PROJECT NAME: **3160 VIA Kachess (SV-14-00001)**

RE: Transmittal of Comments – 3160 VIA Kachess Shoreline Variance application (SV-14-00001)

TO: Lindsey Ozbolt
FROM: Christina Wollman, Planner III *CW*
DATE: May 2, 2014
SUBJECT: 3160 Via Kachess Shoreline Variance SV-14-00001

Sheet Title
 SITE PLAN
 SCHEMATIC

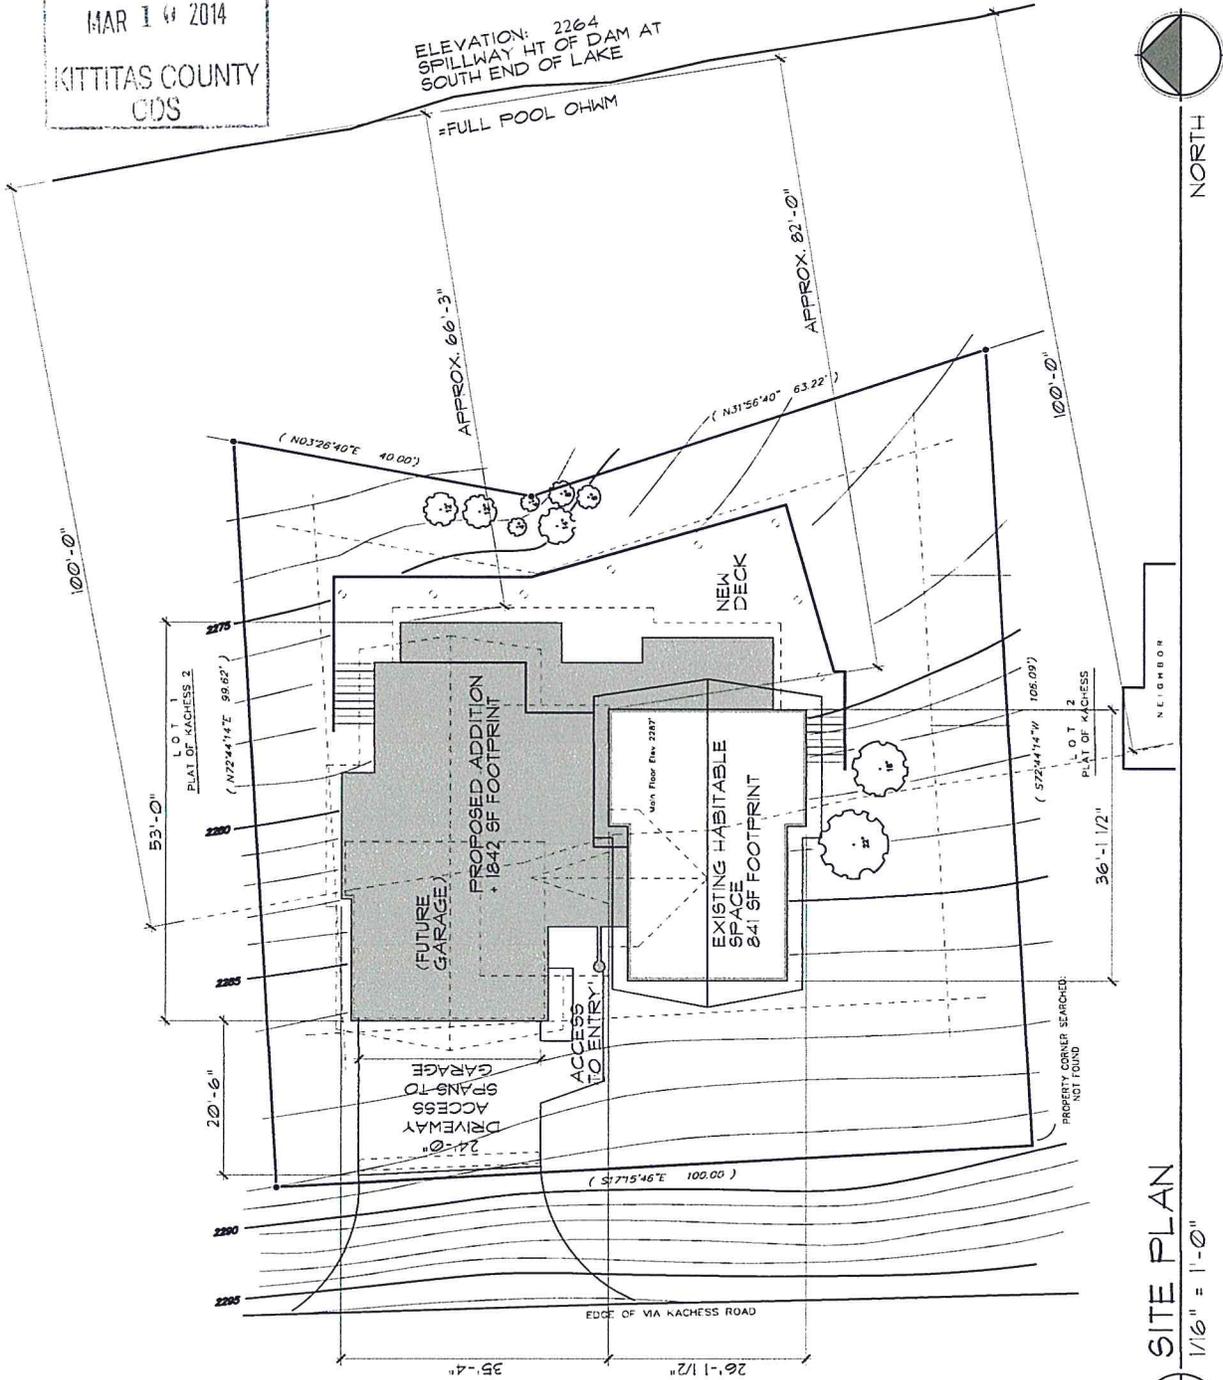
- A. Floodplain: This property received a LOMA from FEMA and is no longer considered to be within the regulatory floodplain. Case No. 14-10-0523A.
- B. Access: This project proposes a new access from the county road. An access permit must be applied for and issued prior to beginning any work within the county right of way. Access must be completed prior to issuance of a building permit.

1. Appears you did not realize that the US Government owns land, managed by the United States Forest Service (USFS), between the ordinary high water level (OHWM) and the original take line. The Bu of Reclamation manages all lands up to the OHWM. The data on Lake Cle Elum shows this type of ownership. but it is not shown on your Lake Kachess map data. The request could affect the US Government owned lands, managed by the USFS, or be in violation of required setbacks from property lines. Property corners were all in place about 20 years ago- not sure now- but it needs to be addressed for allowable setbacks from other property ownership. An educated guess would be that the applicant property line is the Government land boundary, which puts the proposal very close to the property line.
